**Tillbridge Solar Project
EN010142**

**Volume 5
Consultation Report**
Appendix I – Section 42 responses received and Applicant
response
Document Reference: EN010142/APP/5.2

**April 2024
Revision Number: 00**

**FIGURE NUMBER**  
 Figure 8-2

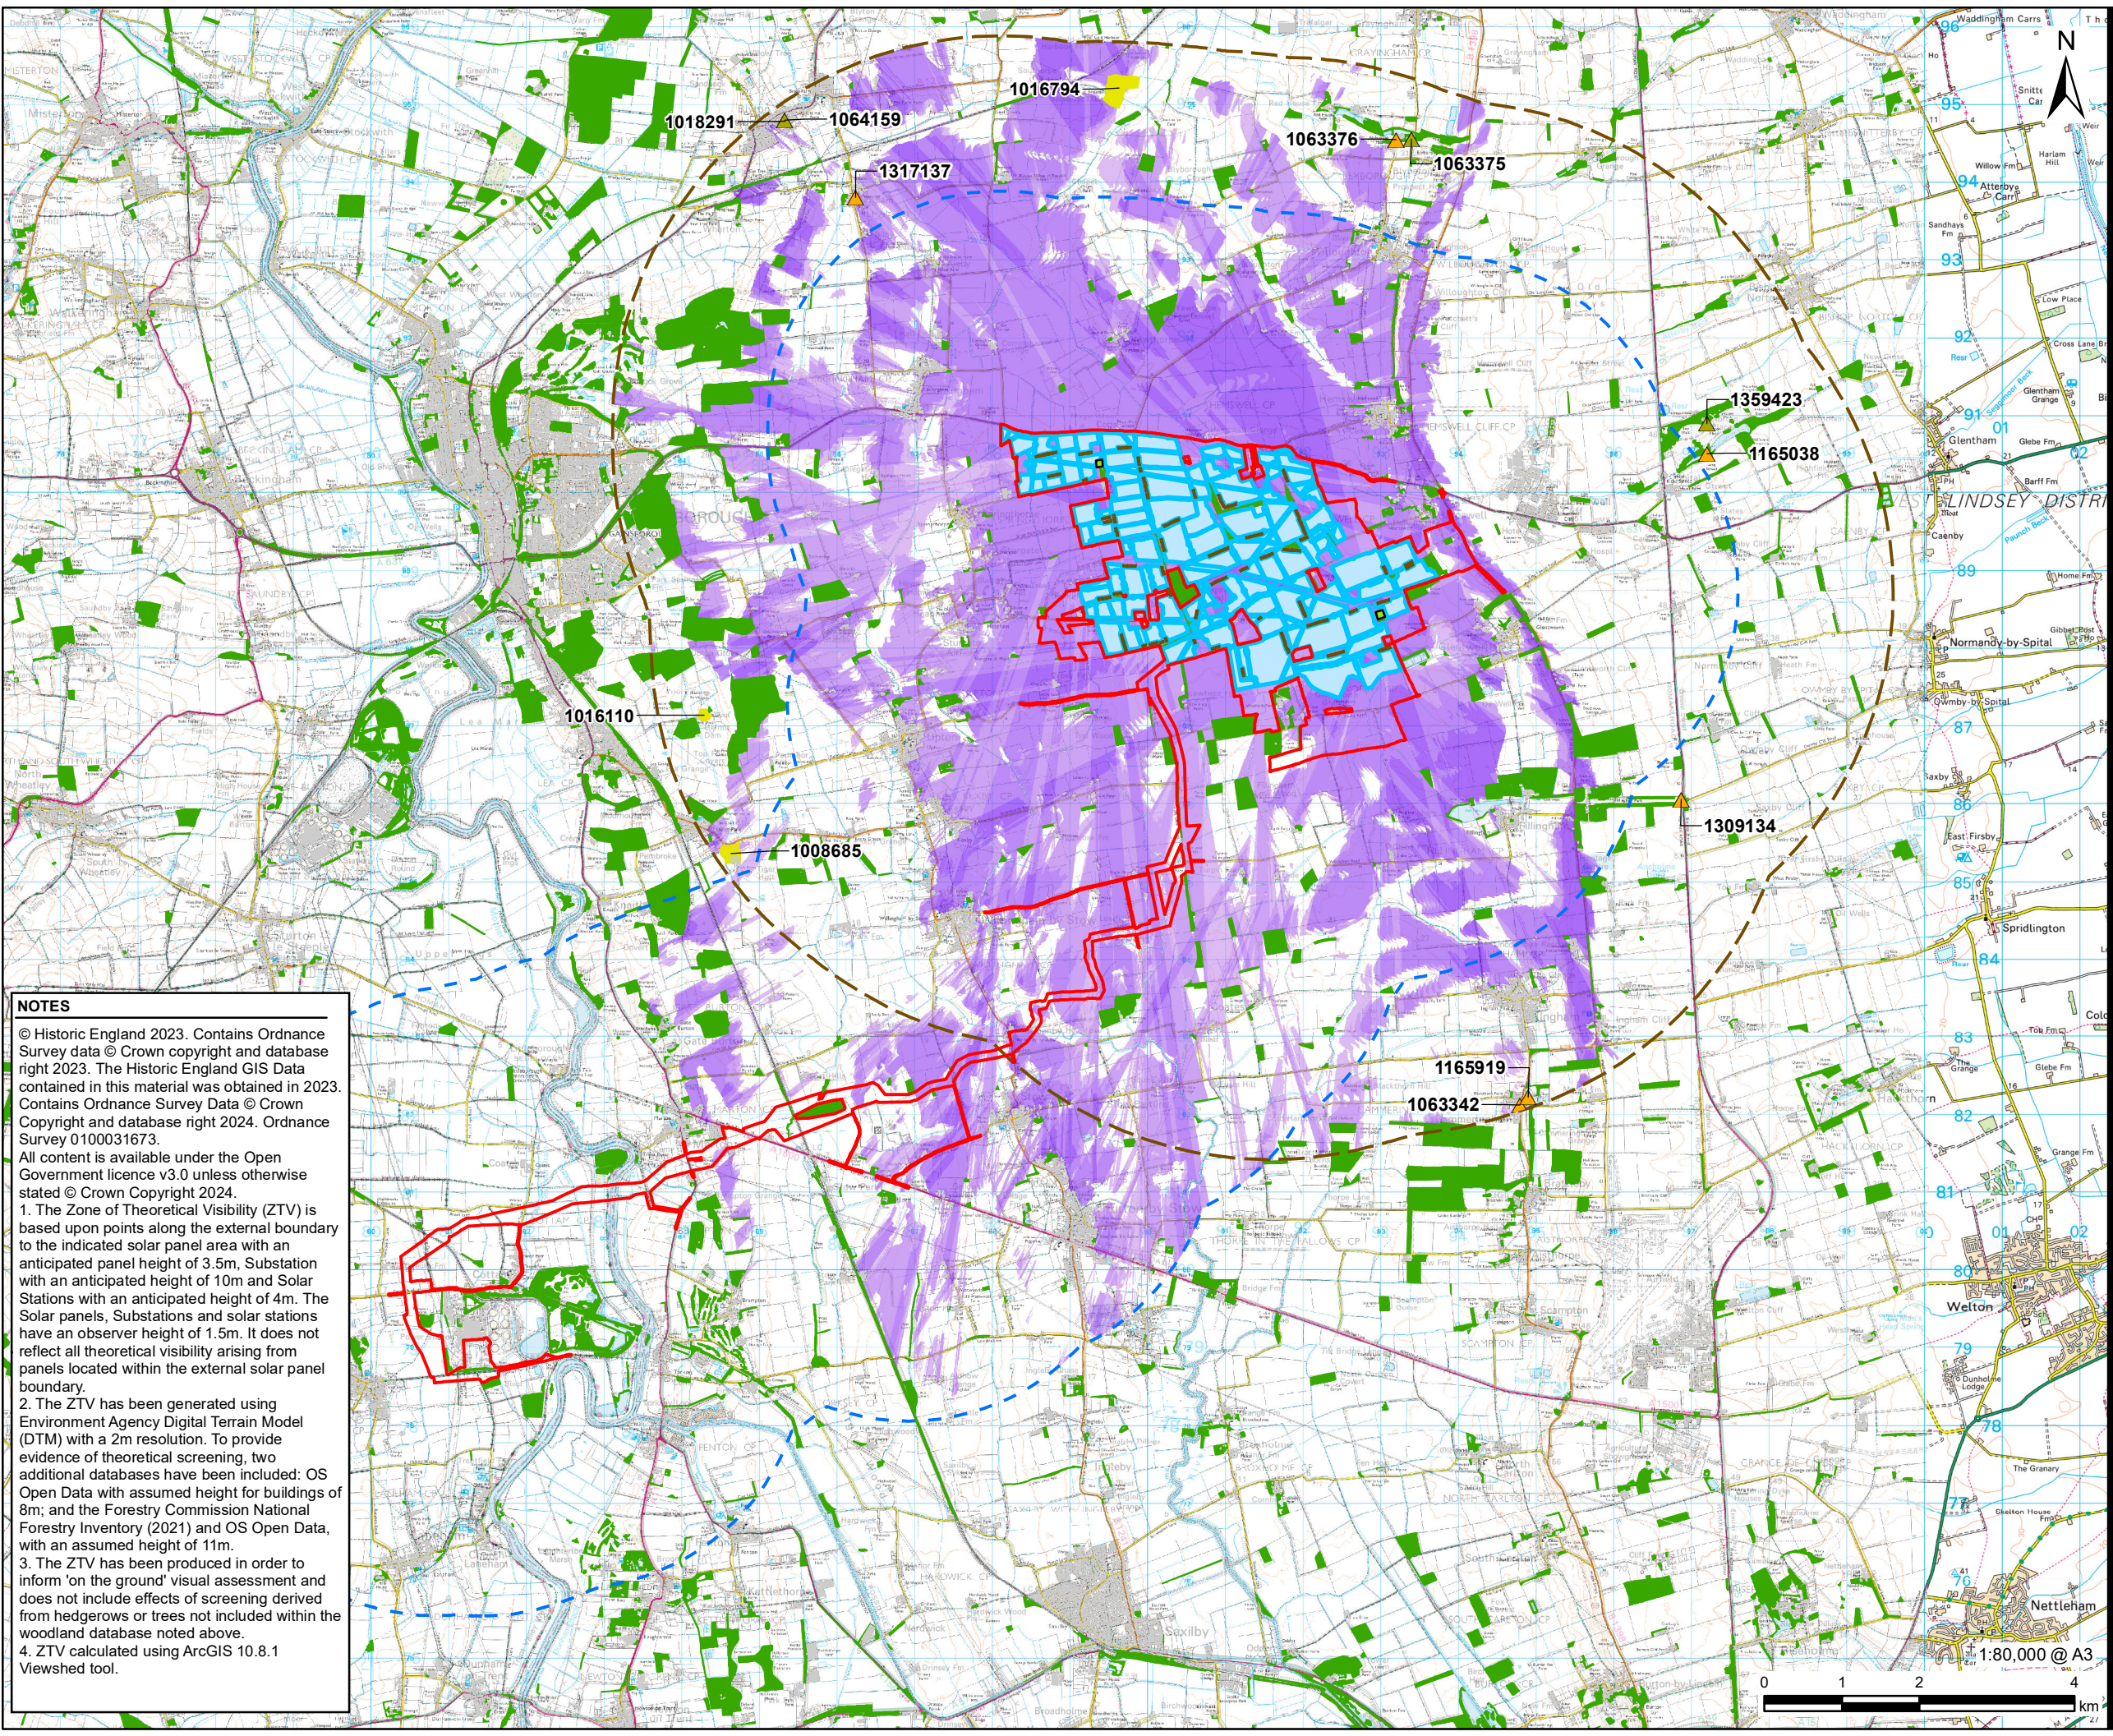
| Respondent | Comment ID | Comment | Scheme Change? (Y/N) | Applicant Response |
|------------------|---------------|--|----------------------|---|
| Historic England | TS_EM_028_001 | The categorisation of designated and undesignated heritage assets into High / Medium / Low requires a degree of nuance. There should be more scope for professional judgement and consultee advice to elevate better Grade ii listed buildings into the high category and to lift better Local List buildings into the medium category. Likewise undesignated archaeological remains once appropriately assessed should be categorised on their merits. Fixed radii for assessment should likewise allow for the application of professional judgement and consultee advice in respect of setting effects. | N | <p>The value of heritage assets has been assessed in Chapter 8: Cultural Heritage of the ES [EN010142/APP/6.1], taking into account advice from statutory consultees as well as considered professional judgement with peer review.</p> <p>Likewise with archaeological remains including those identified during the archaeological fieldwork. Setting effects are assessed and identified where applicable using professional judgement within the 3km Study Area and against the wider Zone of Theoretical Visibility (ZTV) for assets within the 3-5km Study Area around the Principal Site (refer to Figure 8-2 of the ES [EN010142/APP/6.3]),</p> |
